15th November 2011

The Town and Country Planning Act 1990 (as amended)

Demolition of garage and erection of new rear extension.
1 Normandy Lane East Preston

Proposed Floor / Roof Plan

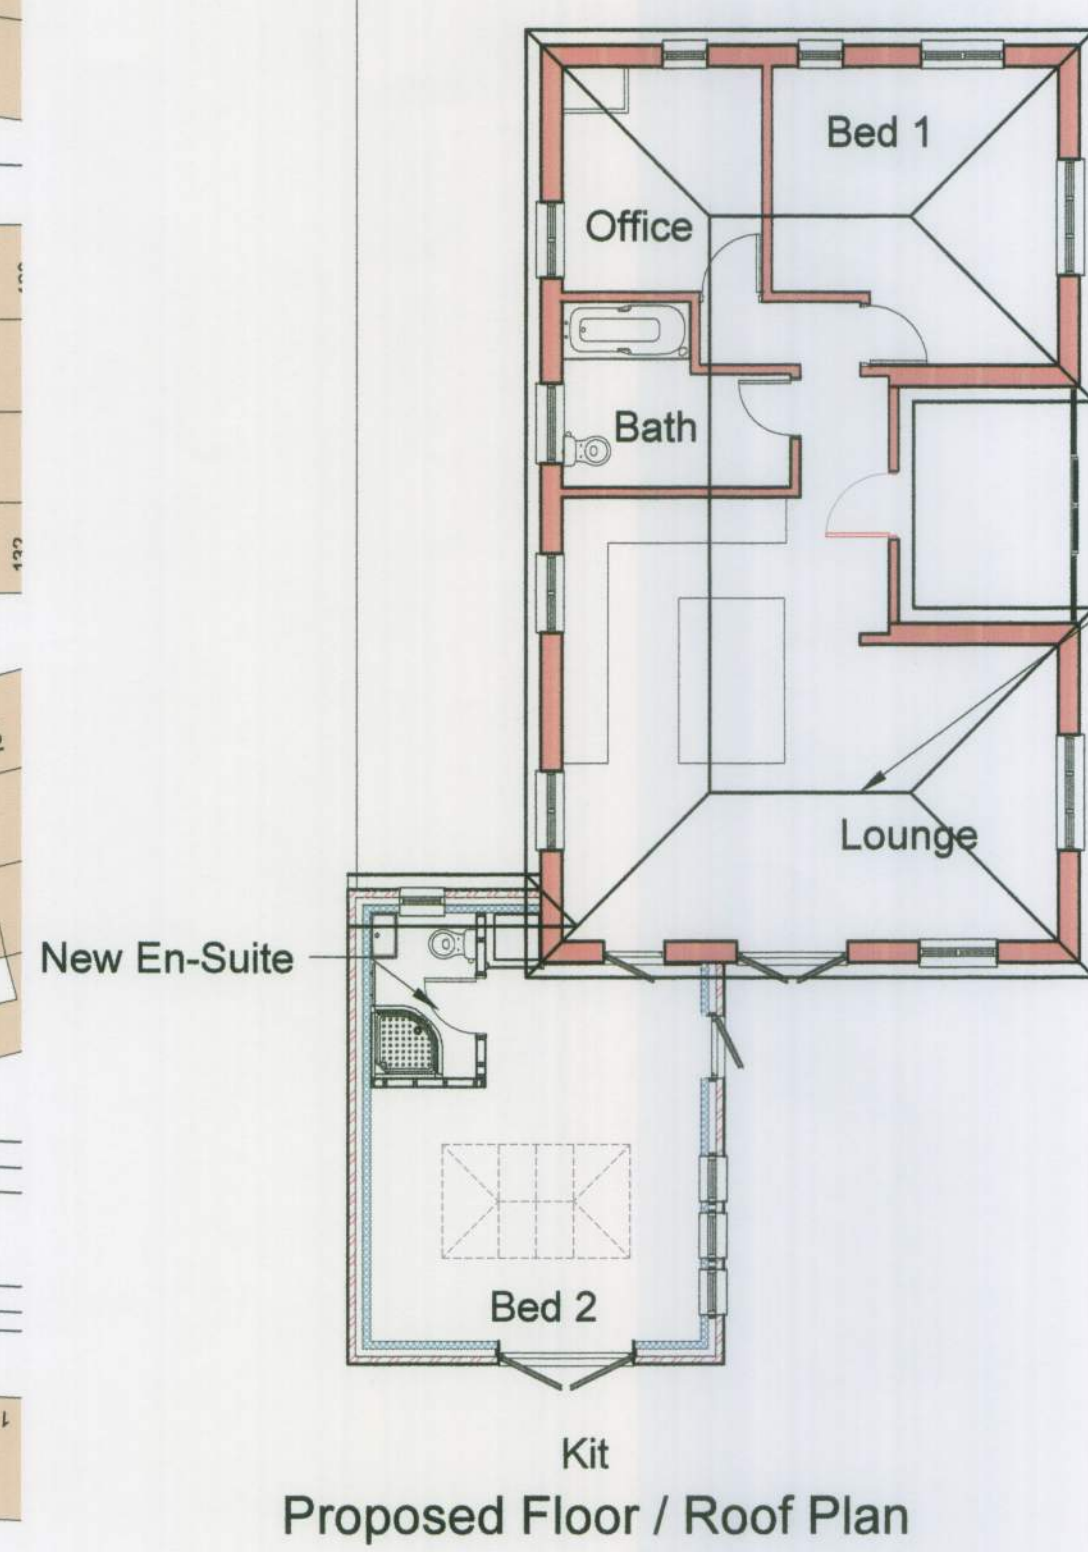
The committee was concerned that in the Proposed Floor / Roof Plan on drawing Dwg001, the proposed extension goes over the northern boundary, as indeed the garage does on the Existing Floor / Roof Plan.

Assuming that this can be addressed in some way by the Planning Officer, the committee wished to raise no objections against this Application.
